Ref: Application number – 3/2022/0667 (Resubmission of 3/2021/1283)

After much consideration I would like to outlay my concerns and objections to the aforementioned application of building a two-bedroom bungalow in the rear of the address of 2 Bushburn Drive.

PROPOSED REAR

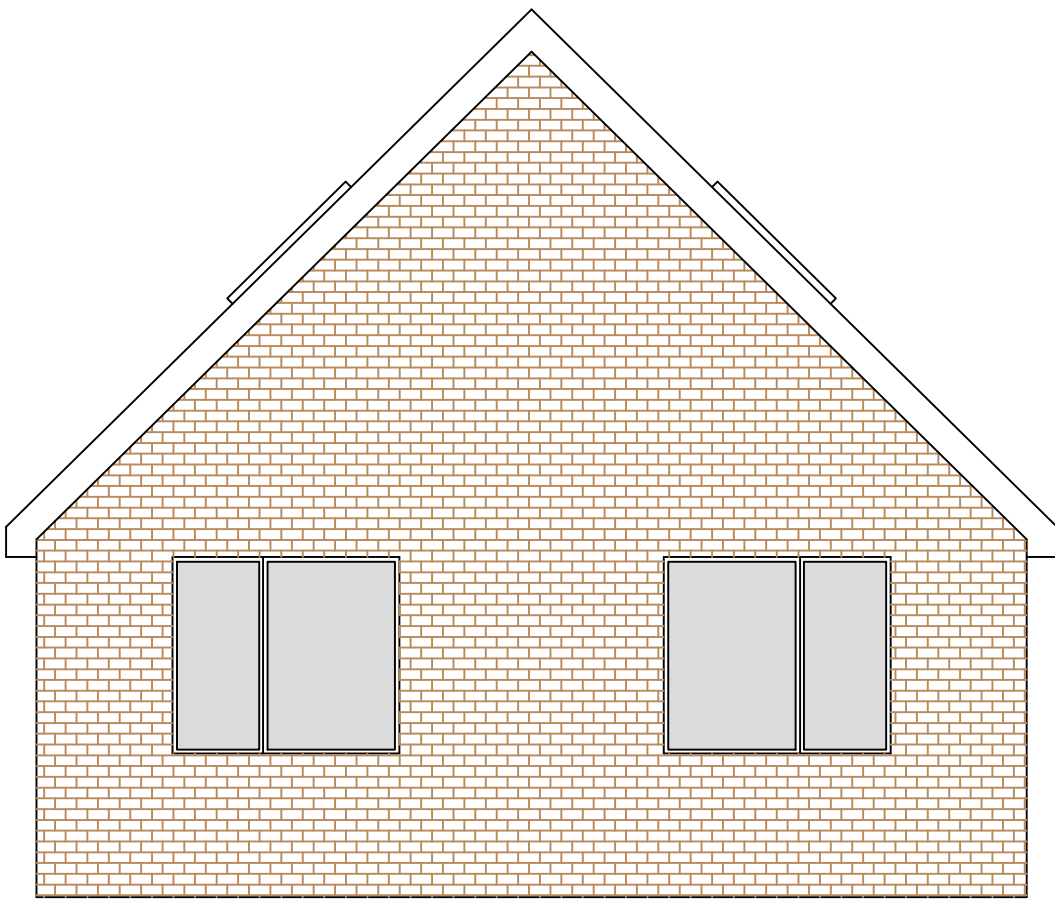
It concerns me that the rear upstairs bedroom will have a Velux type window The privacy that is enjoyed and the height of this proposed development is higher than in the previous submission.

Everyone's property in this area enjoys their own privacy and it can be observed throughout the development. There is no mention if the glass will be frosted. [REDACTED]
[REDACTED]

Proposed Site Plan

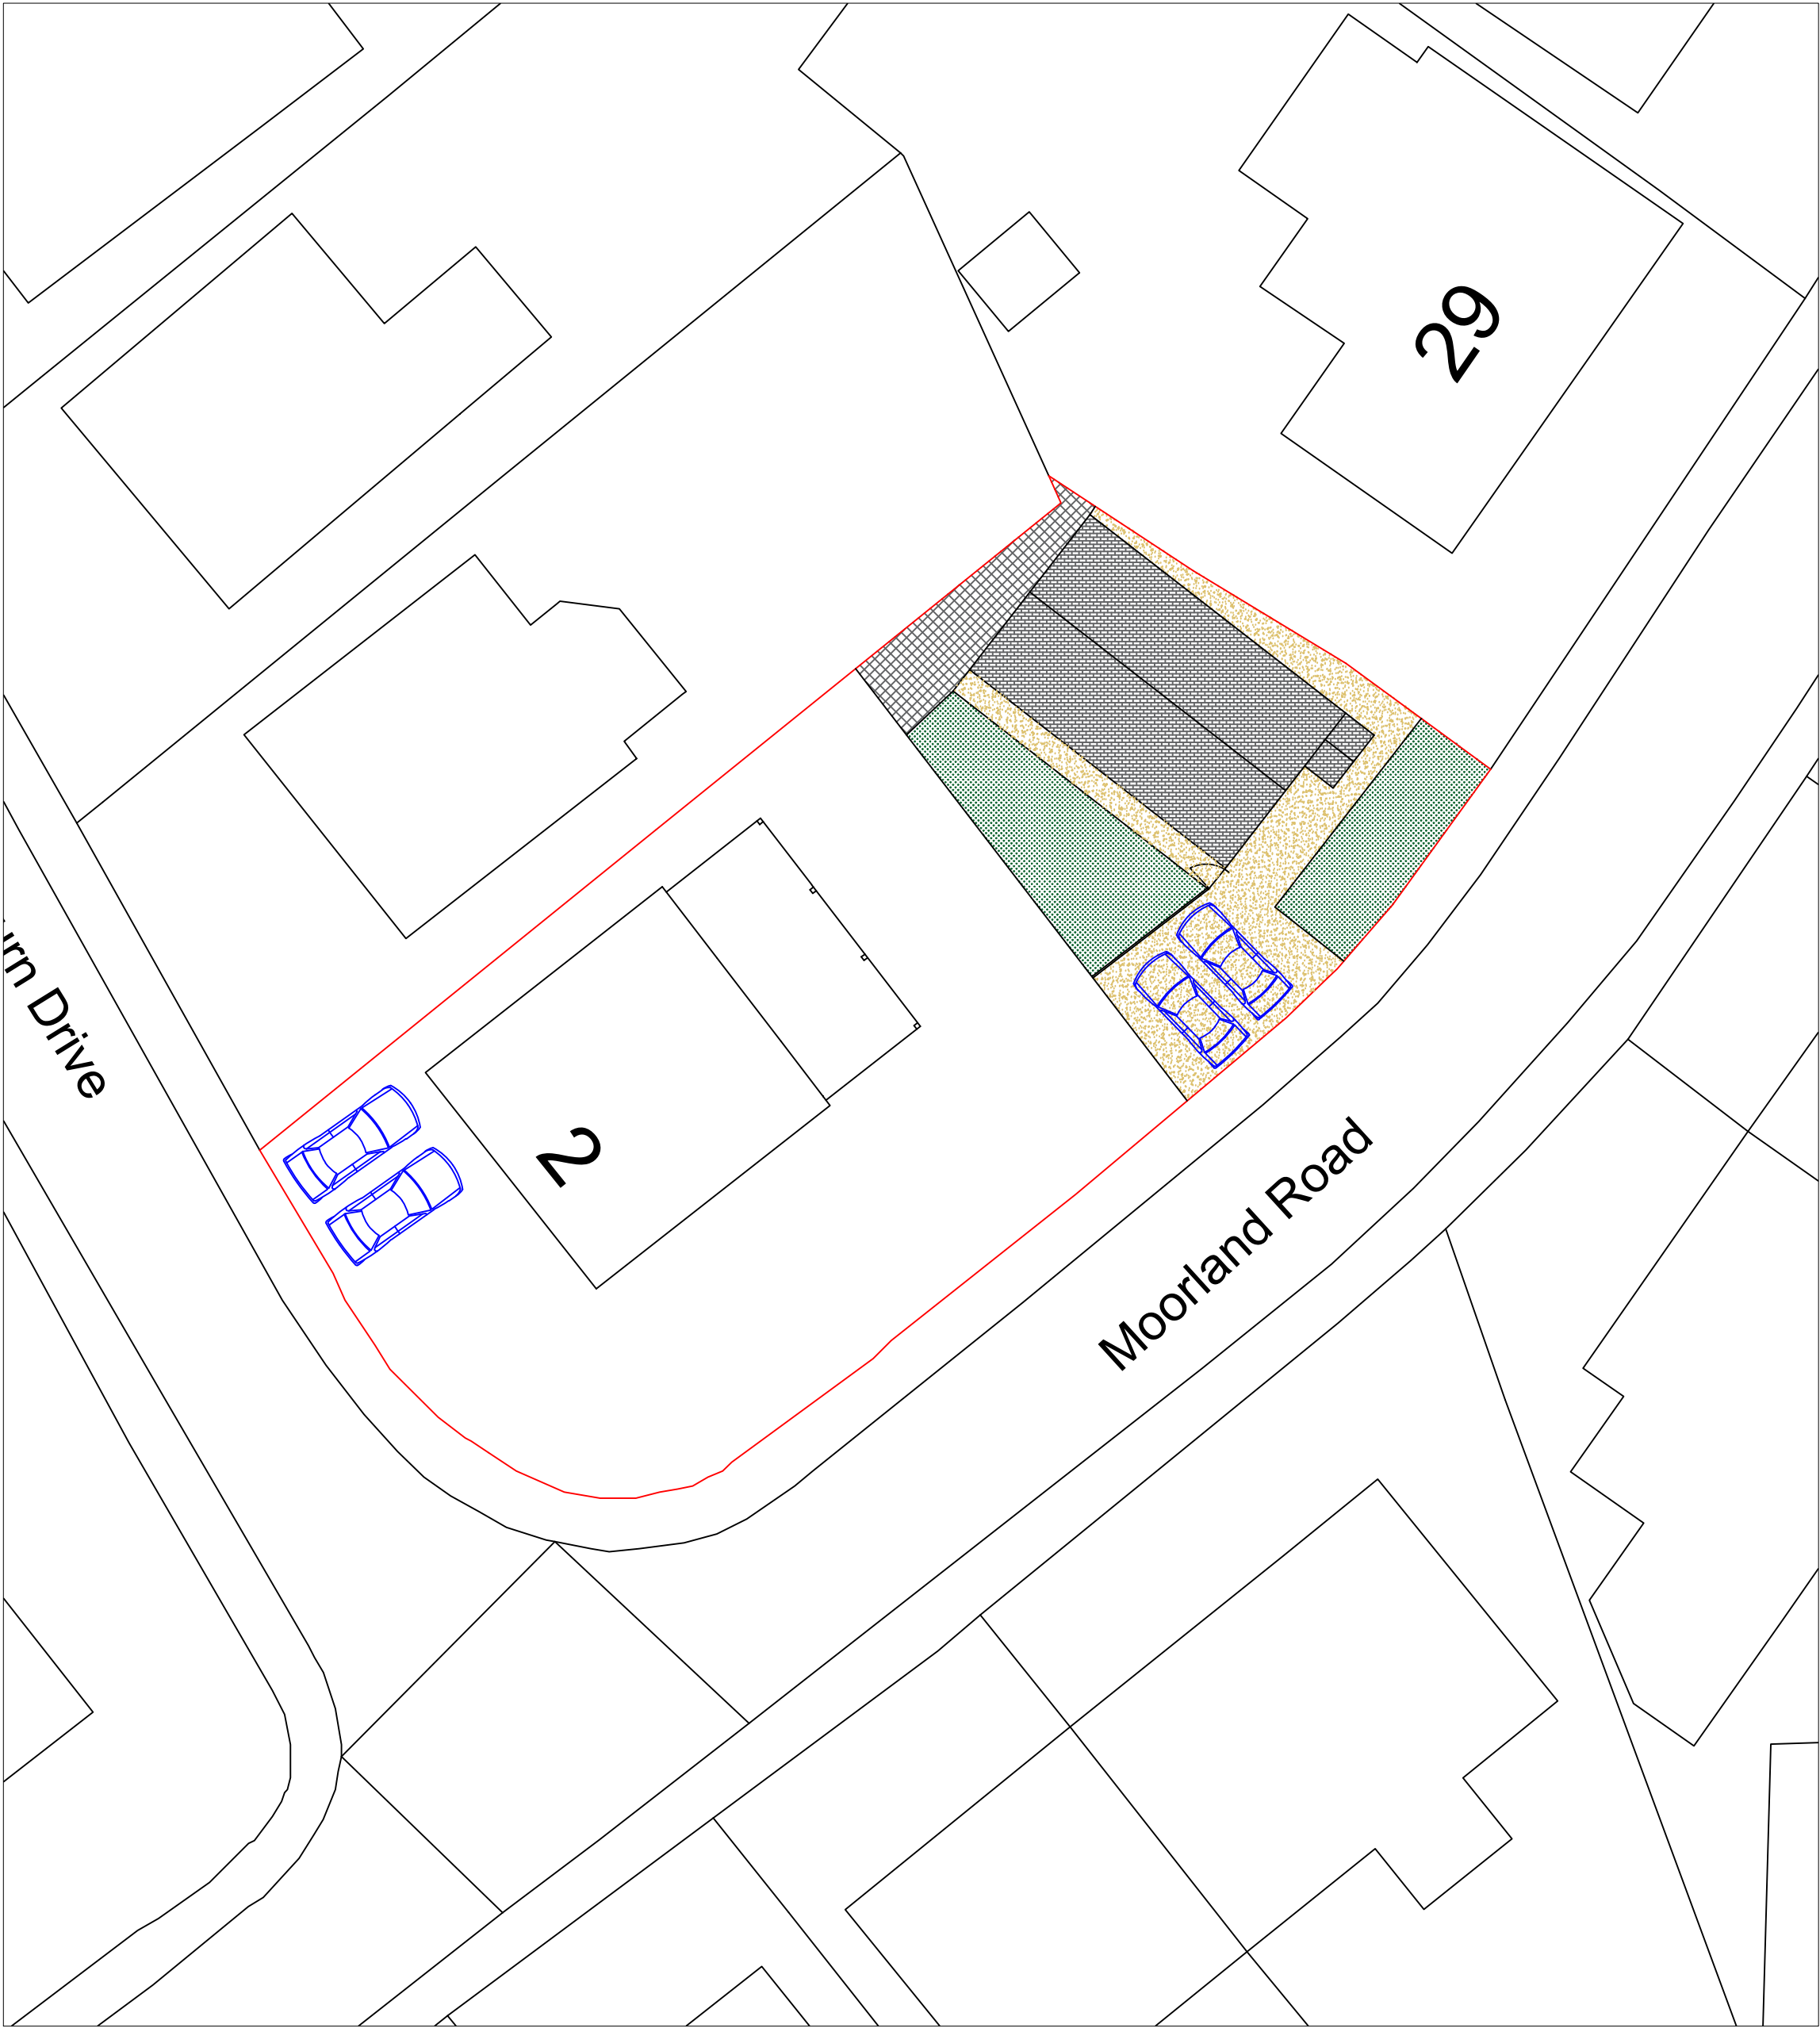
I feel that this new build property would not be in keeping with the rest of the Bushburn Drive and Moorland Road area. According to the site plan I can see that the surrounding boundary of the new dwelling will be quite tight especially to the east and north of the property. This will not be in character with the rest of the area and in this particular part of the estate it will look dense while the rest of the area will look normally spaced out.

There doesn't appear to be any planning regarding the drainage of rainwater from surface and guttering. Currently, surface water drainage from the applicant's property.

[REDACTED] The proposed site plan nor application do not indicate how the applicant wishes to border the property. For example, with what height fencing or hedges and how far to the pavement such a border would be erected potentially causing [REDACTED] a blindspot [REDACTED] Also, I am concerned regarding where the applicant's commercial vehicles will be parked as they are currently usually parked on the site of the proposed dwelling. So indirectly, this development will cause loss of on-street parking.

On the one hand while some of the points above touch upon [REDACTED] residential amenity being affected and I'm sure for other neighbours also, I also feel there is little way in residential amenity for the potential buyer of the proposed dwelling in comparison to the rest of the householders in the area. The dwelling isn't afforded much gardening land and or storage and with very little room around the east of the property would make it difficult to maintain the property. The way the proposed dwelling has been positioned on the proposed site plan hinders the building process also and I object [REDACTED]
[REDACTED]
